From: Richard Temple
Sent: 24 January 2018 16:29
To: Planning.Responses
Subject: FW: Ref Planning Application FP/268/17/PL

Richard Temple | Senior Planning Officer, Directorate of Place, Arun District Council | Location: Phoenix House, Arun Civic Centre, Maltravers Road, Littlehampton, BN17 5LF

Subject: Ref Planning Application FP/268/17/PL

Figure 7 – Landscaping Masterplan

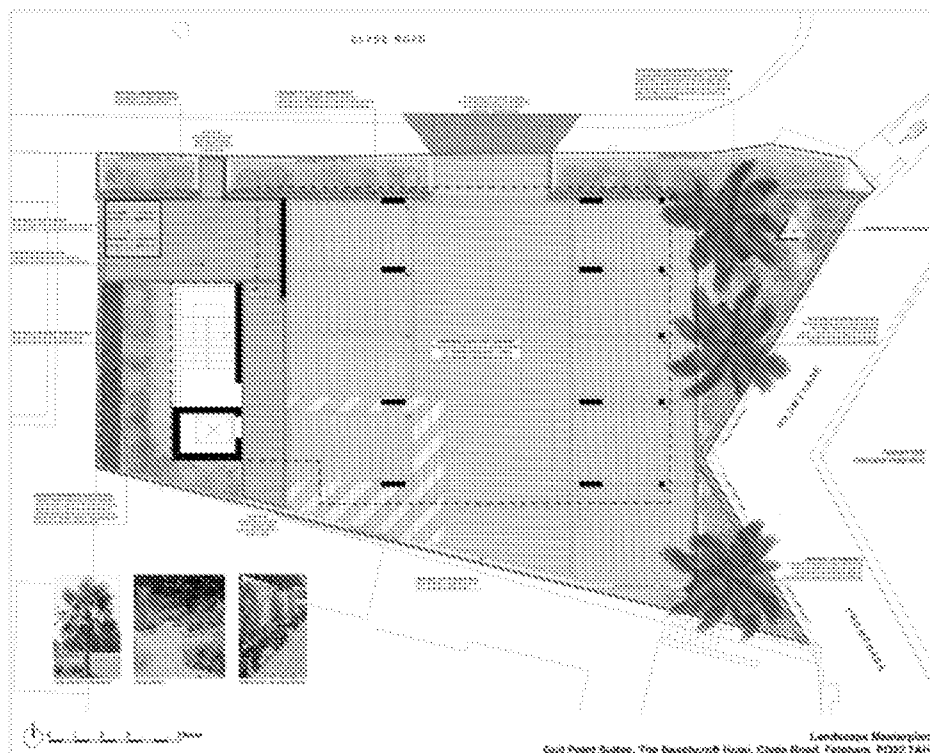
Thank you for bringing my attention to the note on your Landscape Masterplan drawing and the reference in 4.7 and bp2 of 4.11 of the strategy.

Whilst these references allude to the proposed low timber wall, they do not give sufficient importance, in my opinion, to the job of keeping the sea out. I would have expected to have seen the wall shown in both of your Elevations drawings as well as the Sections drawing (unless that is it is concealed by the red boundary line!).

However, can I please draw your attention to our landscaping drawing and landscape design strategy, both these documents make reference to a hardwood timber wall behind the existing sea defence wall, within our landscaped area along the eastern boundary, to act as a secondary line of defence. This timber wall will be slightly set back from the existing sea defence wall at the back of the promenade and will be some 500 mm higher than the existing sea defence wall.

Low Timber Wall (Plan)

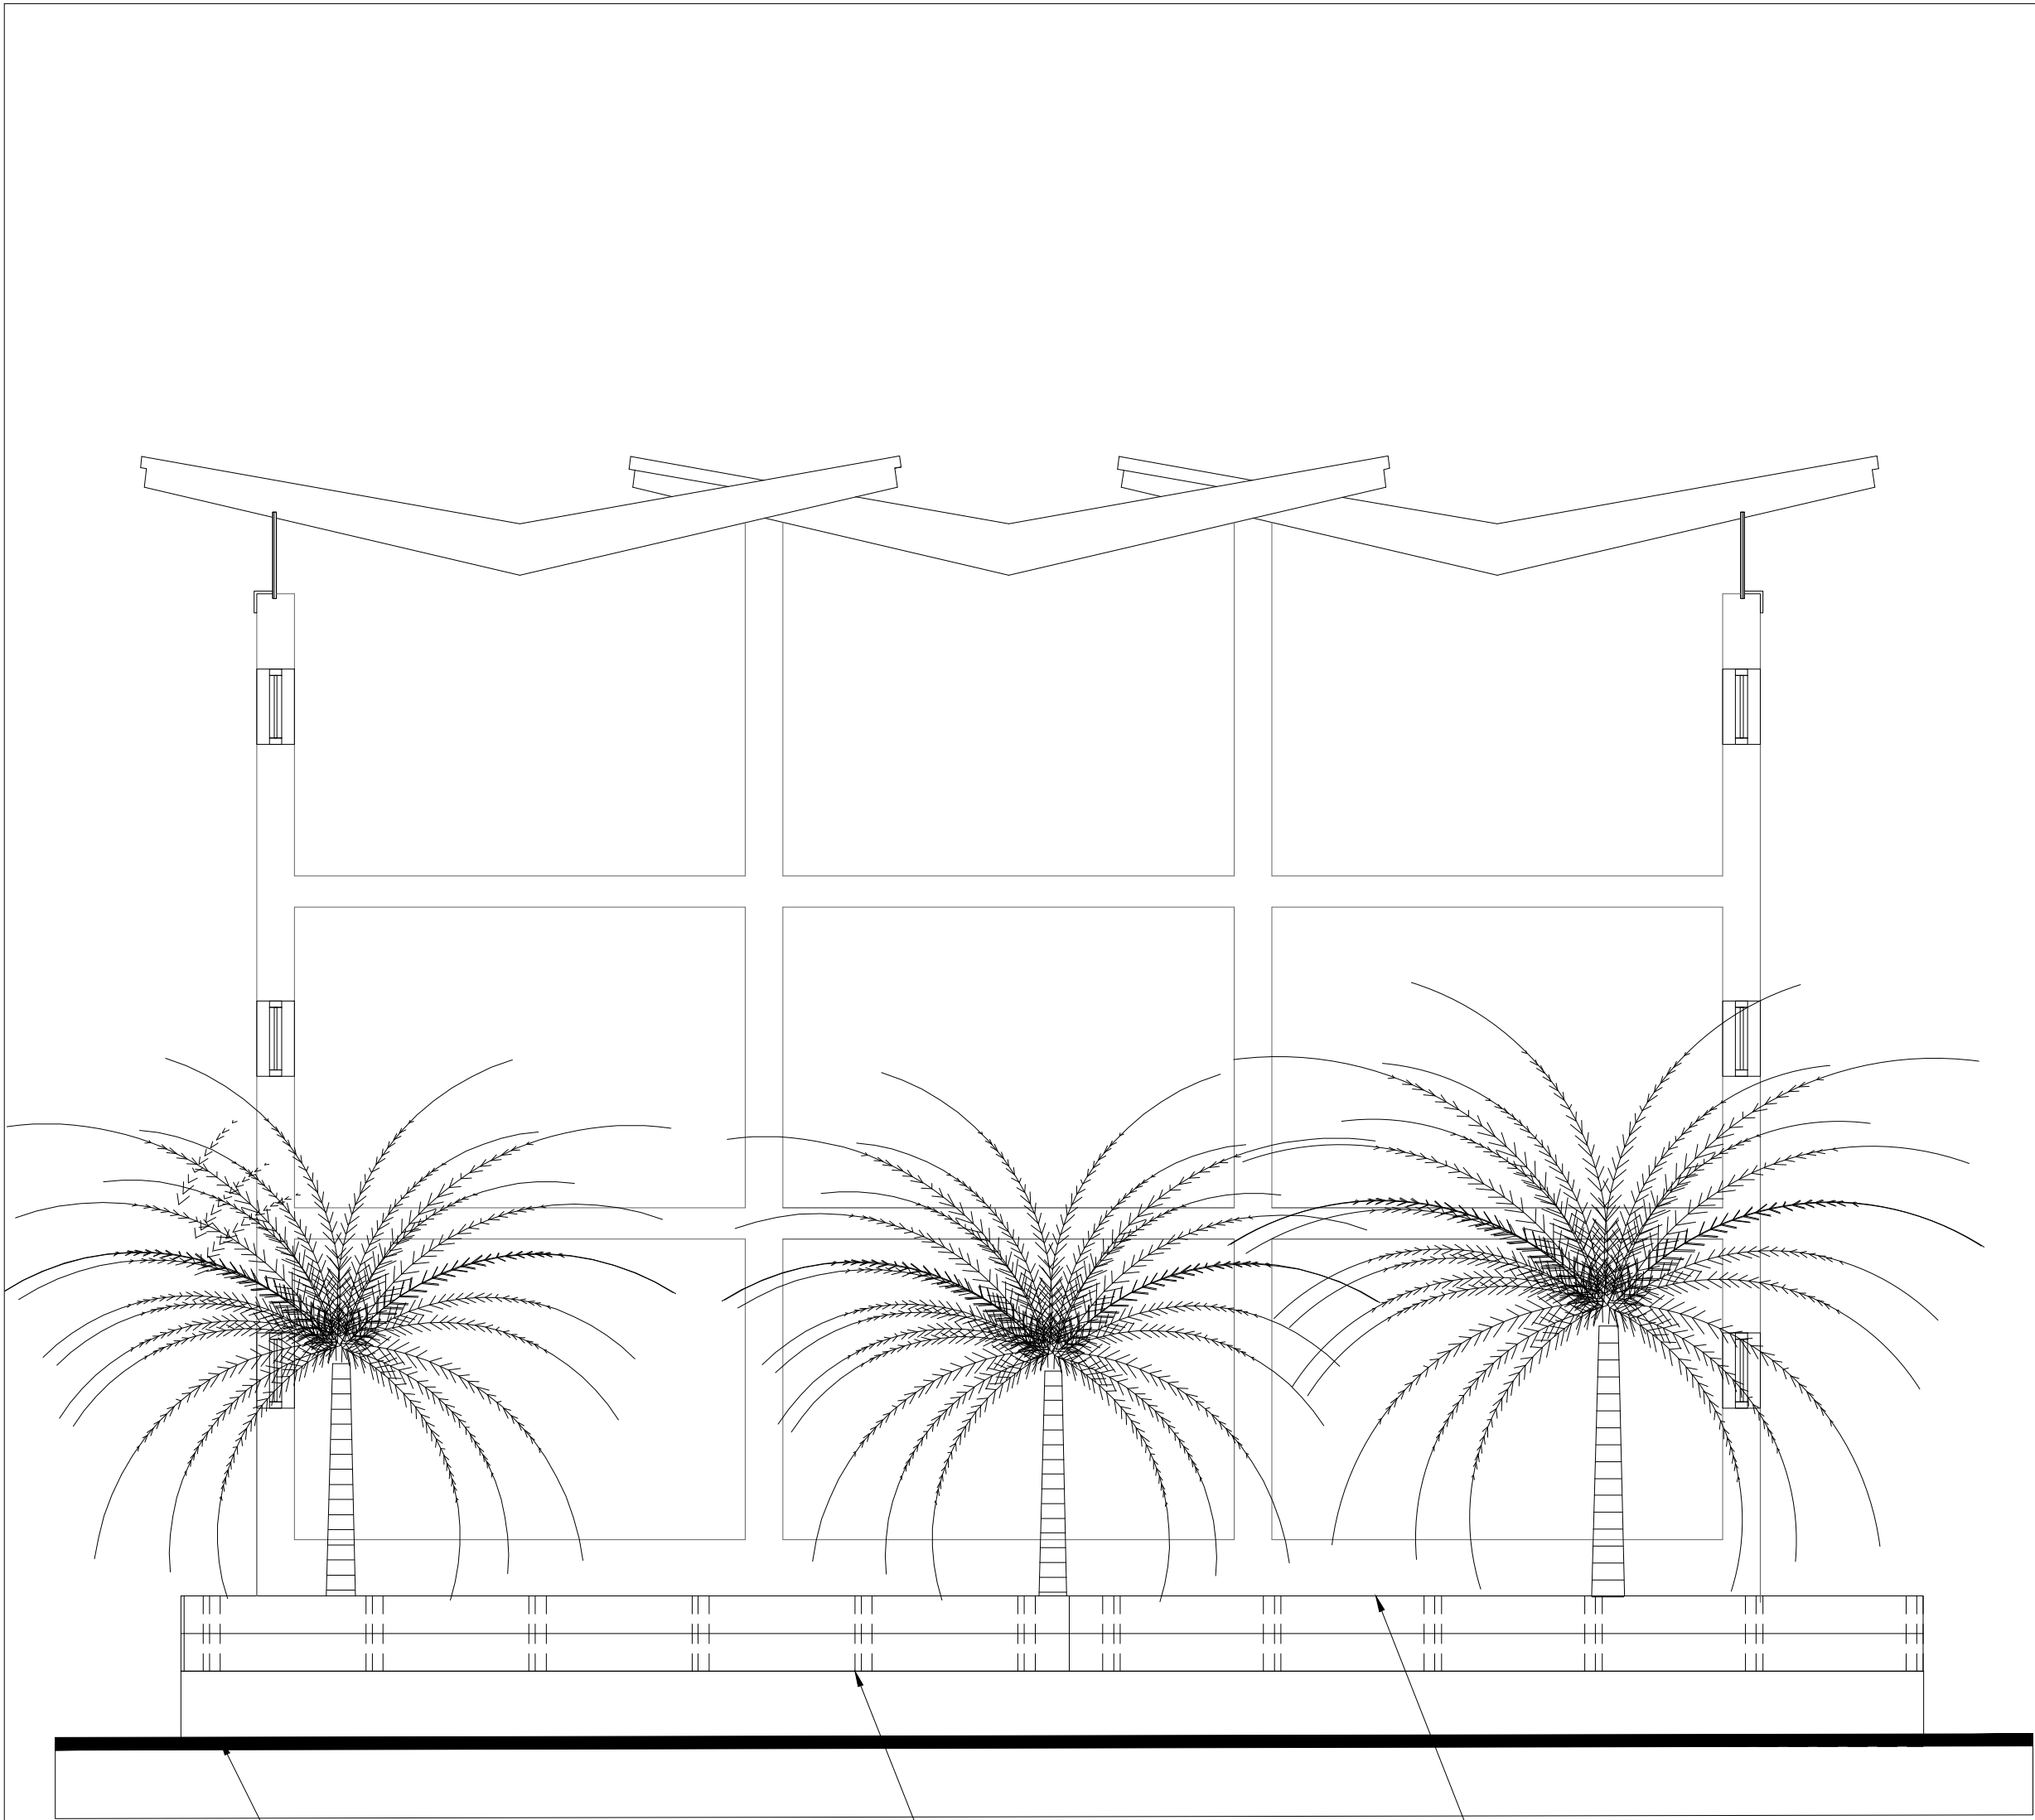
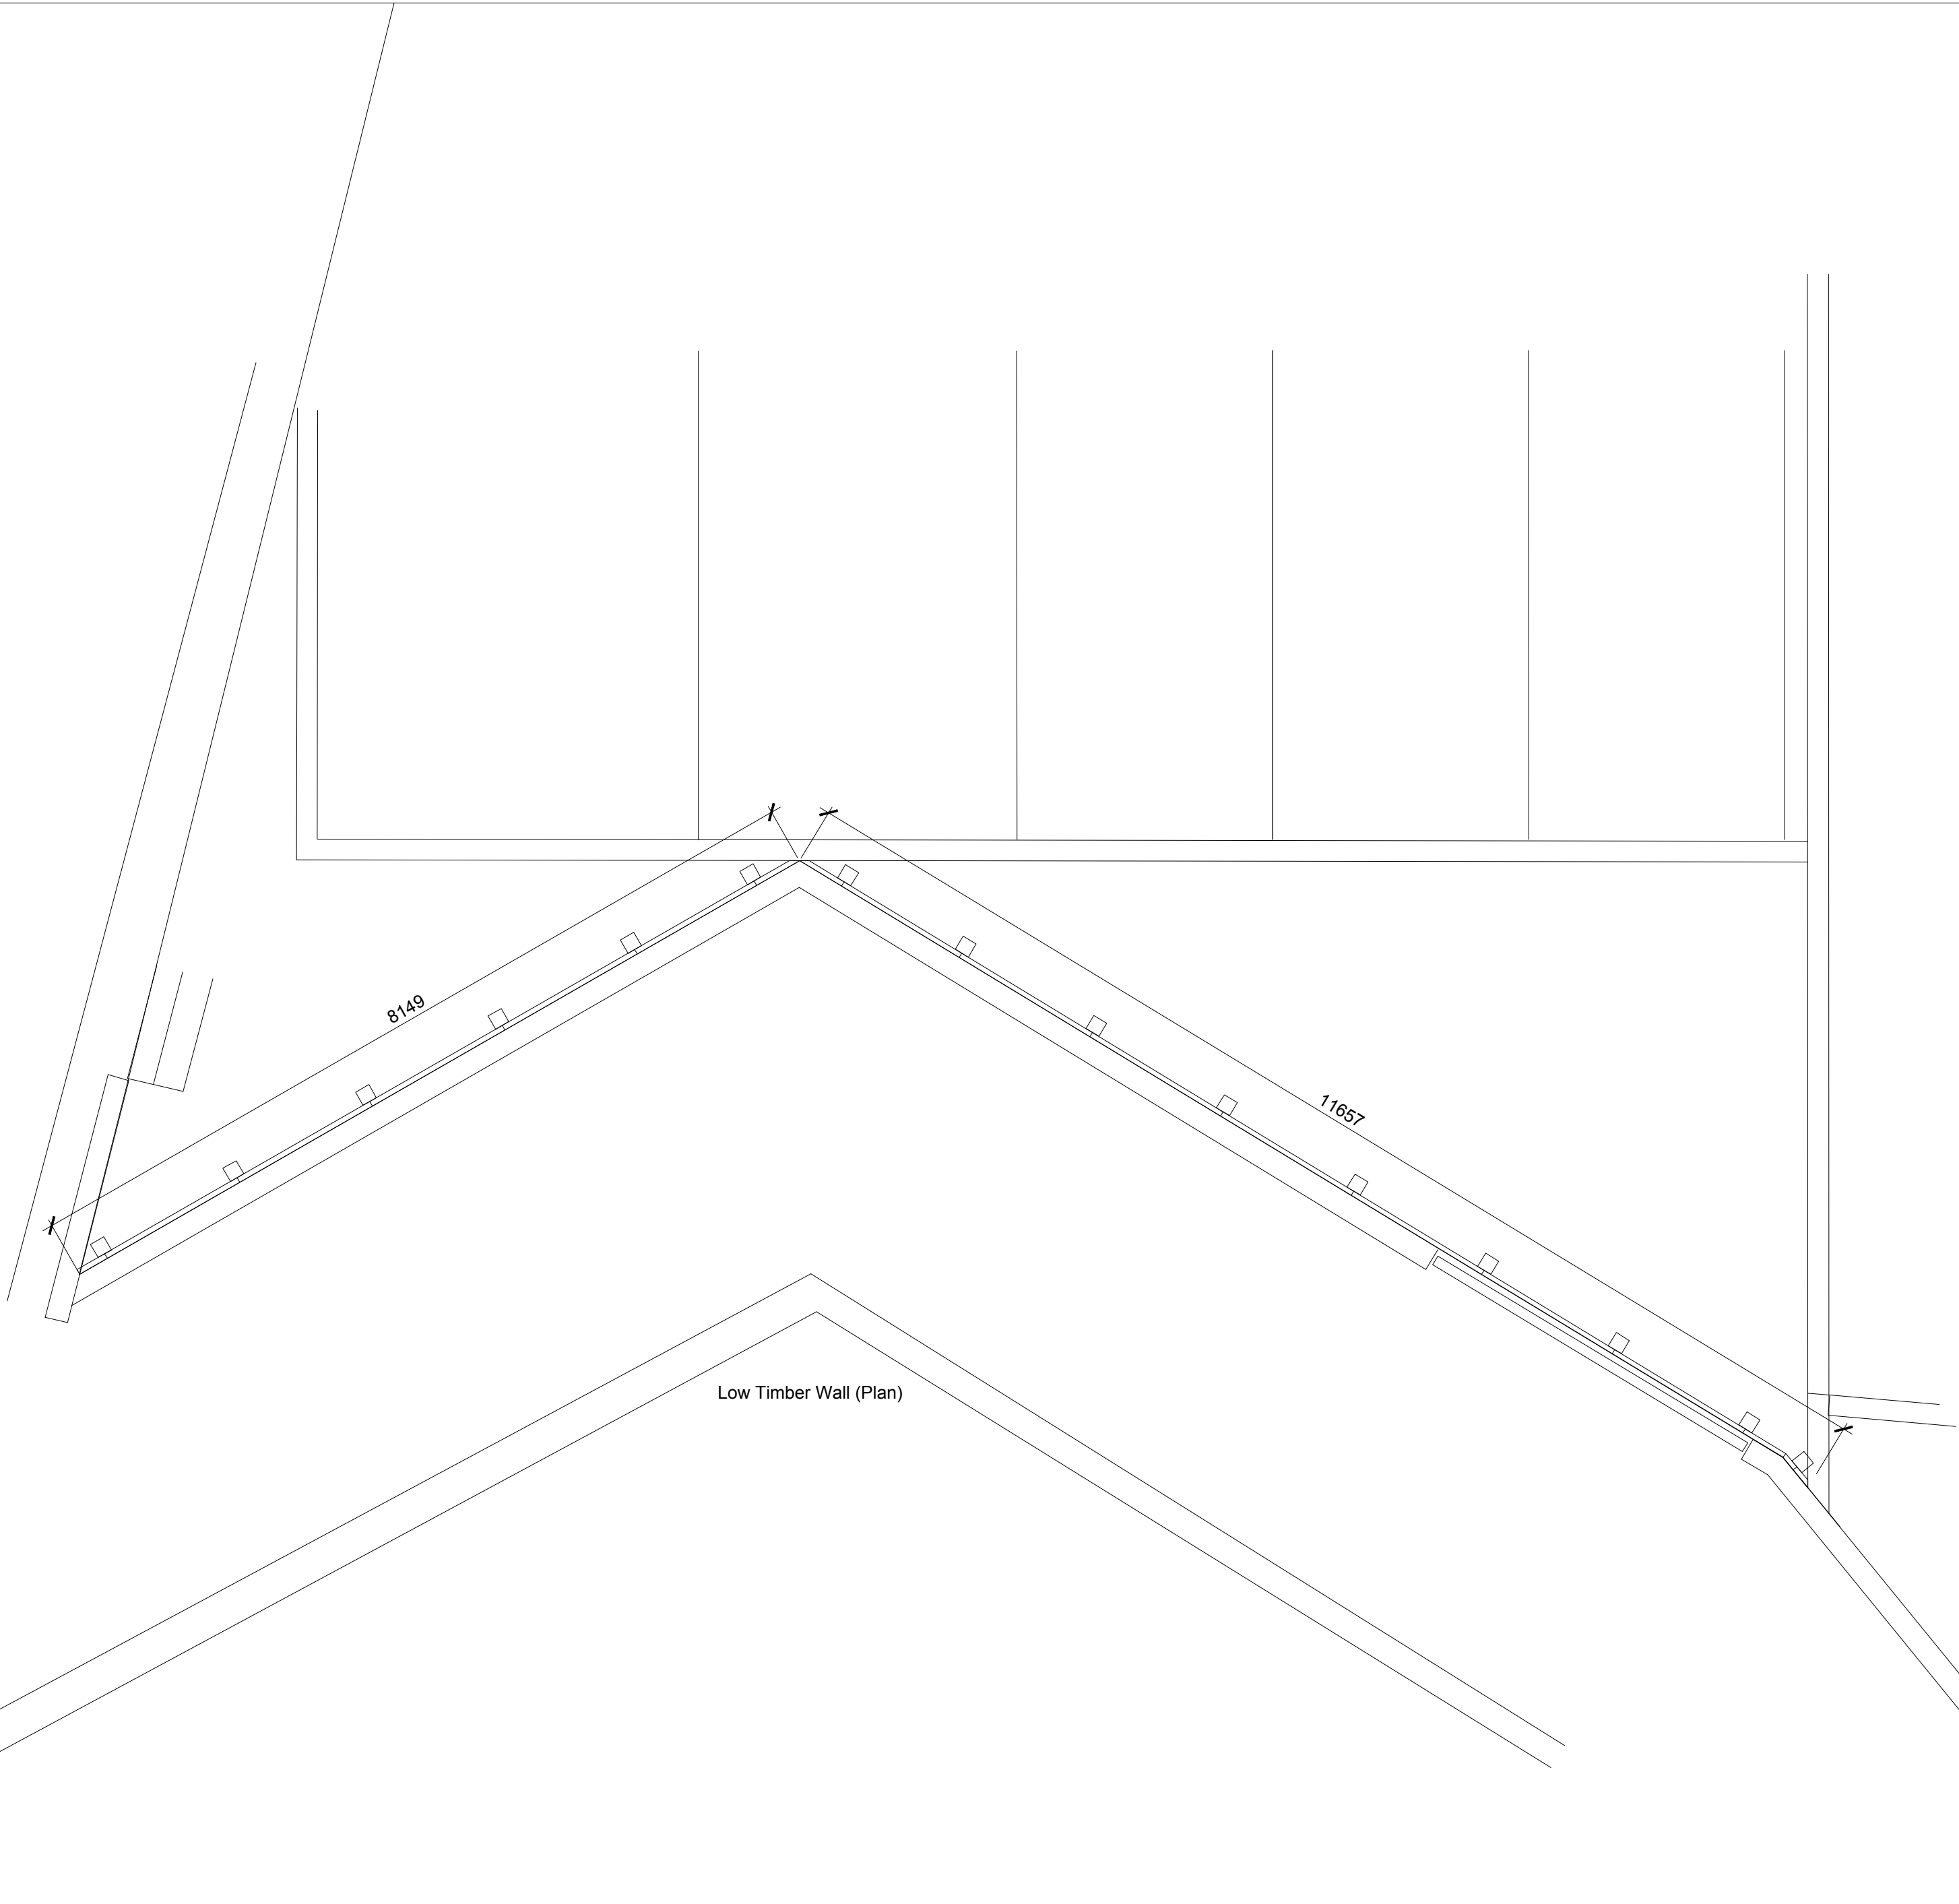
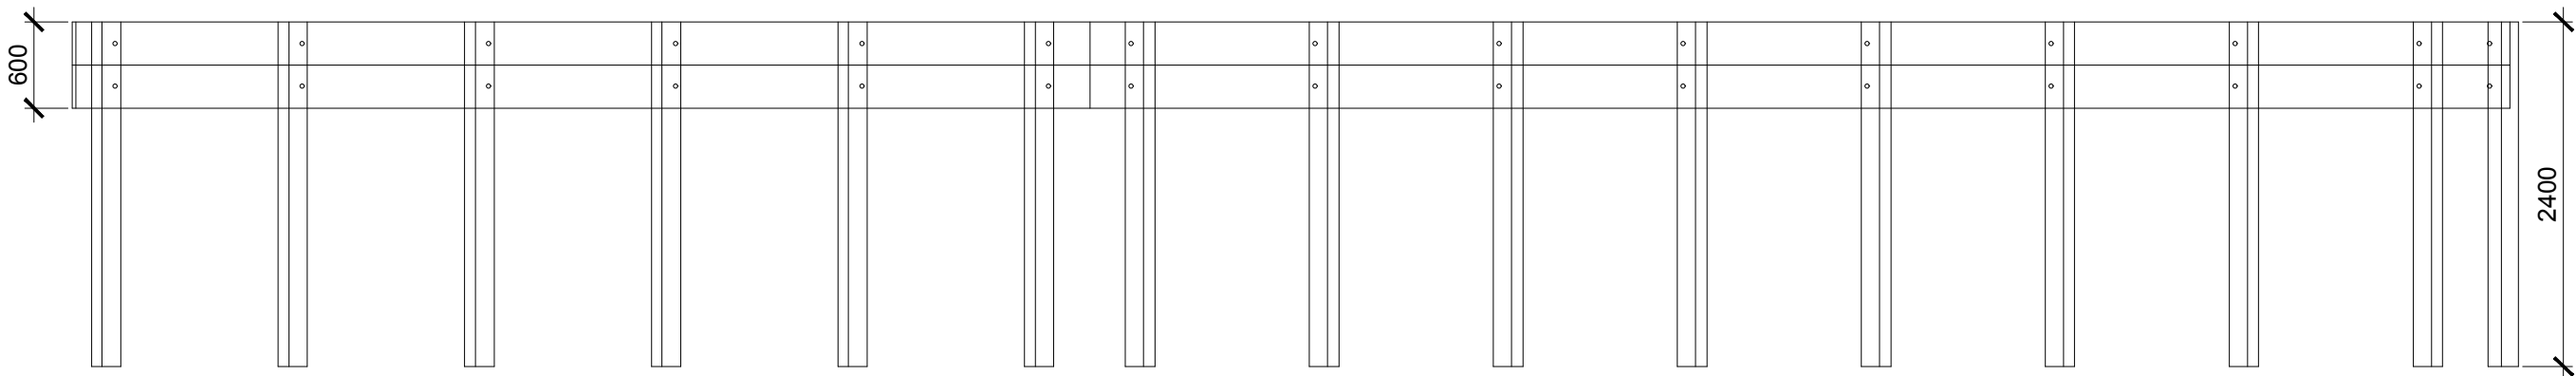
However, I would urge you to change the min 1500mm centres to "max"

I would also suggest that you reconsider the fixing detail. As it stands, with the fence tight up against the back of the seawall, you wouldn't be able to fix the planks to the posts - suggest that you fix the posts against the wall then start the planks on top of the wall. You may have considered that we wouldn't like this encroachment over the seawall but I think it is preferable to your current detail. Sitting the bottom plank on top of the wall would also provide for a better seal too.

I assume that you'd concrete the posts into the ground, as I wouldn't want to put more loading onto our seawall by fixing into the back of it. Please also consider that digging out for the concreting in may be a little problematic - I'm not sure what the construction would have been in the 1960s when the seawall went in.

Thanks for your reply. We will take on board your advice. I will issue an amended drawing to you and Richard Temple tomorrow.
